# **OXFORDSHIRE COUNTY COUNCIL'S RESPONSE TO CONSULTATION ON THE FOLLOWING DEVELOPMENT PROPOSAL**

**Application no:** 16/00263/F

**Proposal:** Demolition of Buildings 485 and 488 and the erection of 43 dwellings with associated parking, infrastructure, landscaping and public open space.

**Location:** Dorchester Phase 6, Heyford Park, Camp Road, Upper Heyford.

### **Proposed levels and drainage layout**

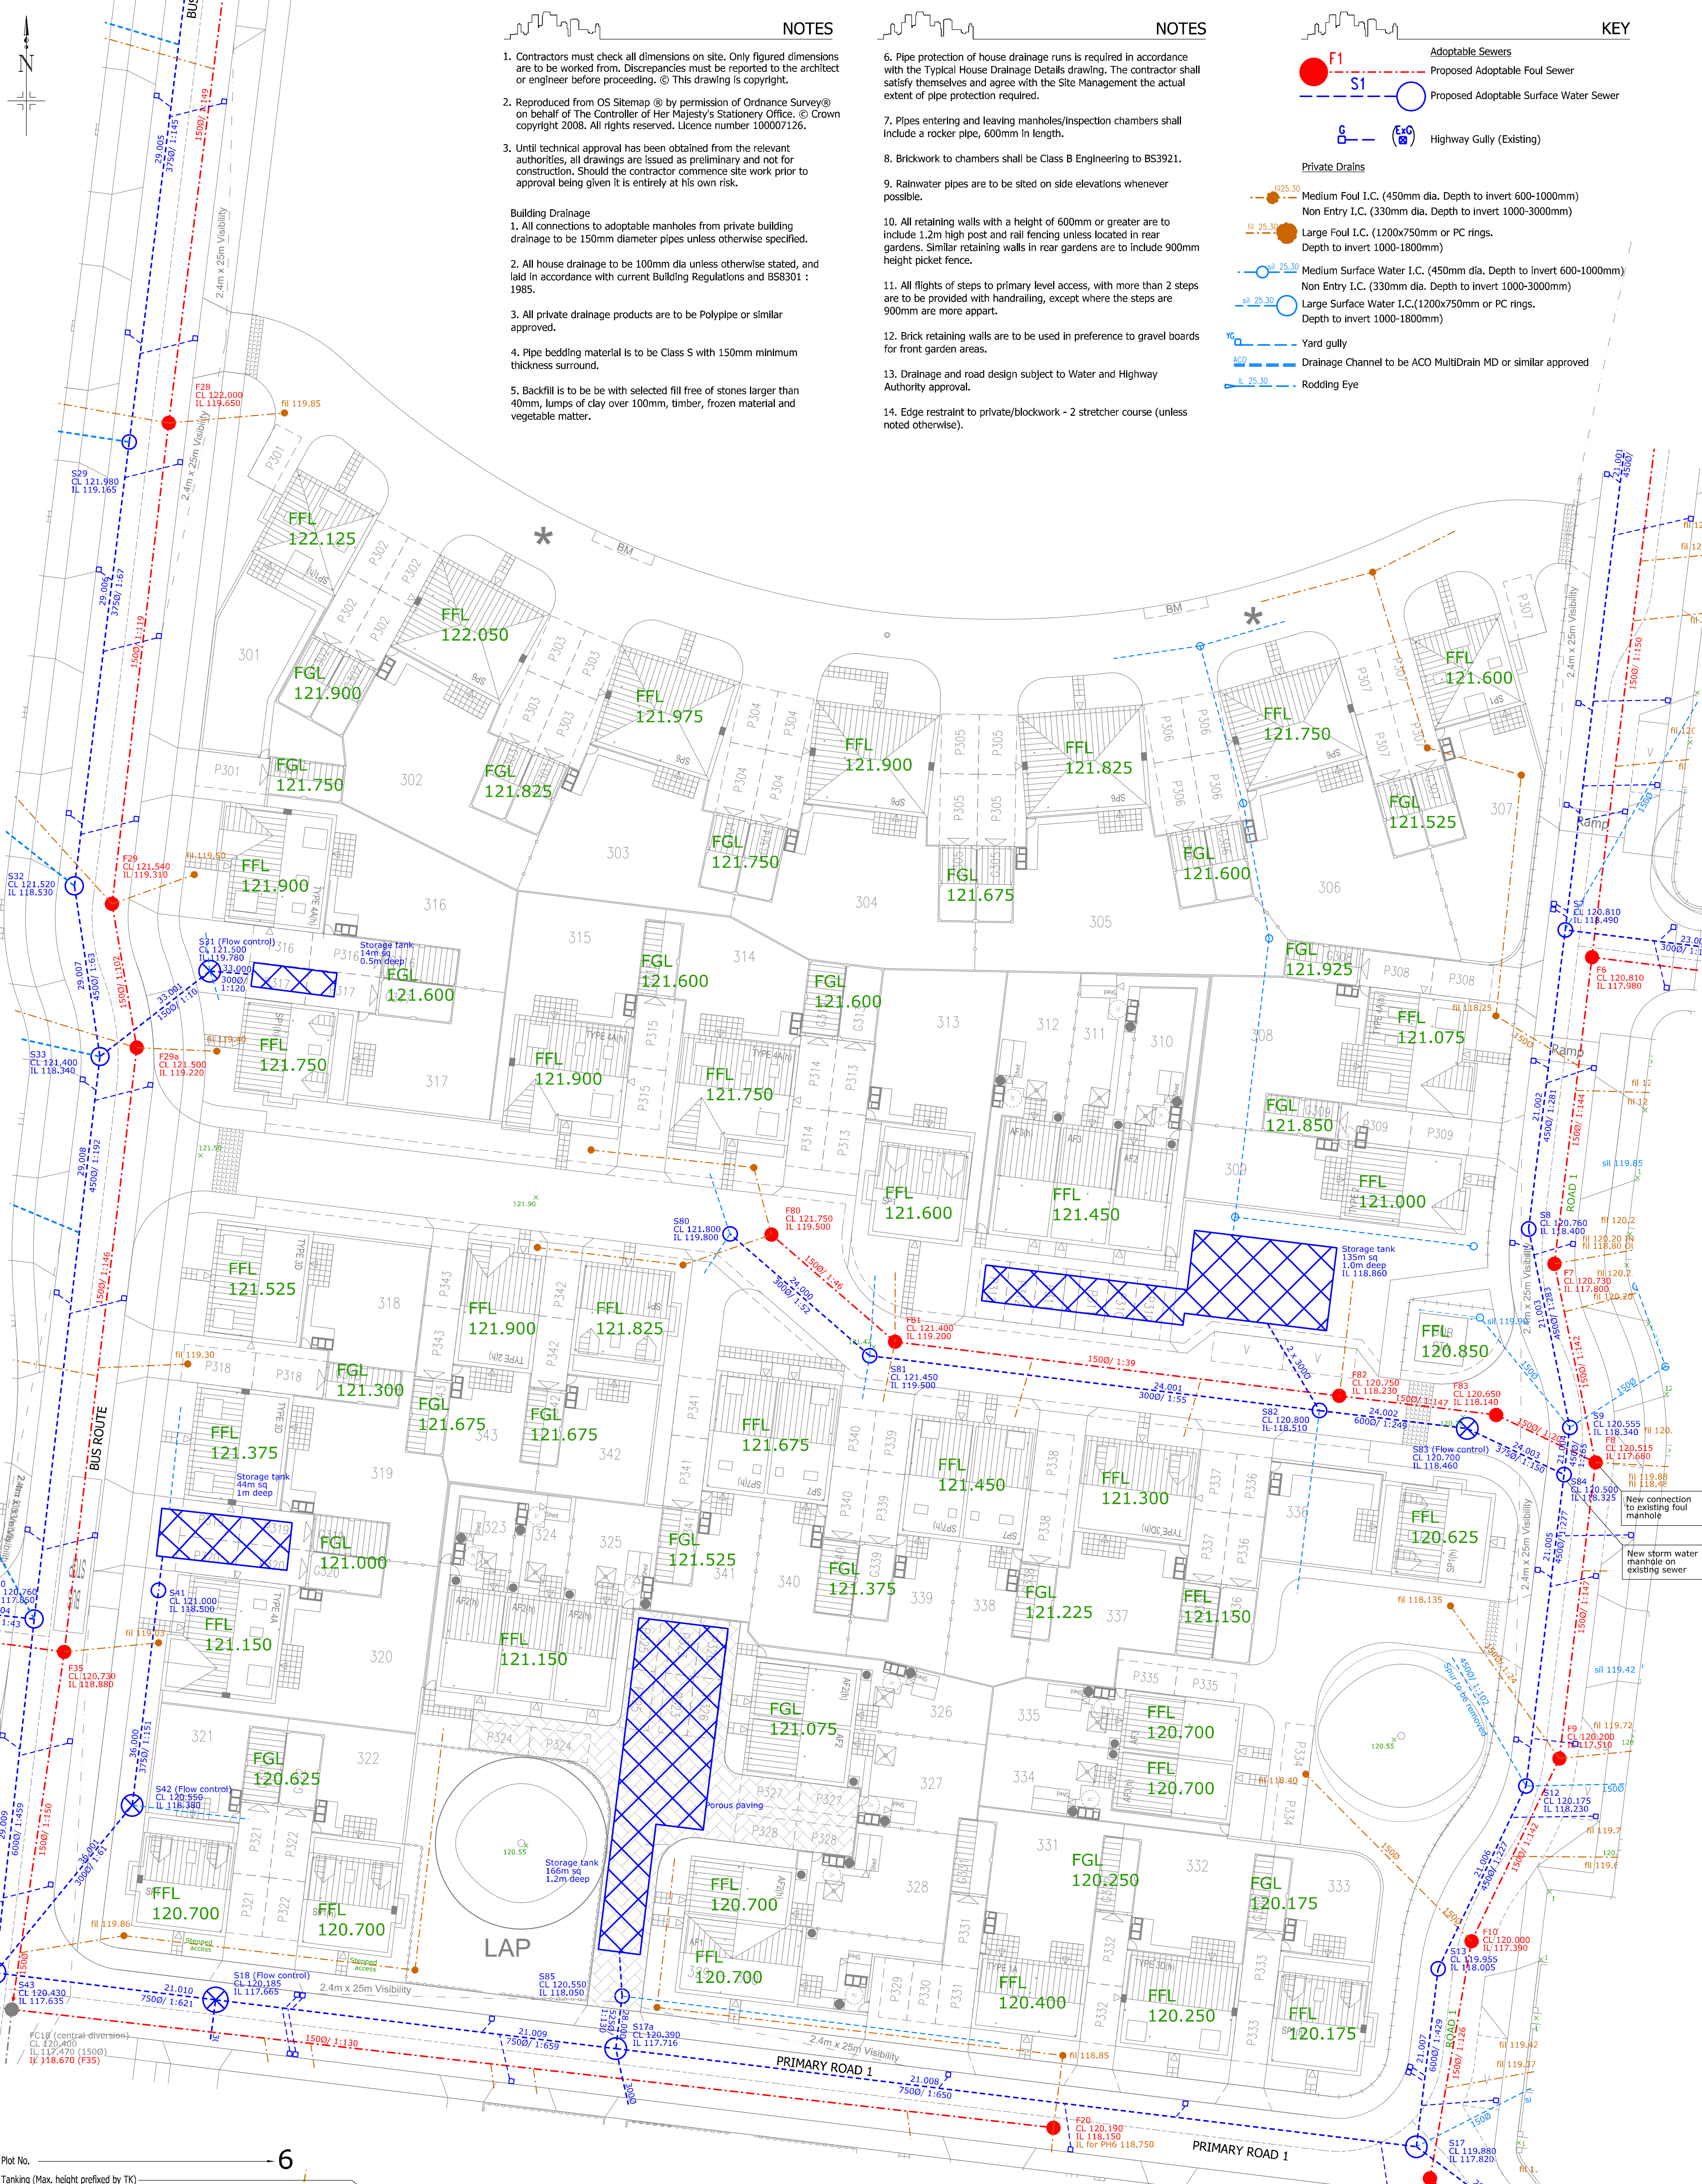
The XP Solution default settings for min and max backdrop manhole height have been altered from the default settings and set to zero. It is not clear if this reflects the proposed actual situation, or what the reason is for altering the default settings to zero. **Reason for objection.**

The calculation sheets provided appear to be in support of proven simulation of the 1/100 year storm. Calculation details will be required of the simulation modelling of the 1/30 year storm event with respect to the site flooding service criteria of no surcharge from the drainage system. **Reason for objection.**
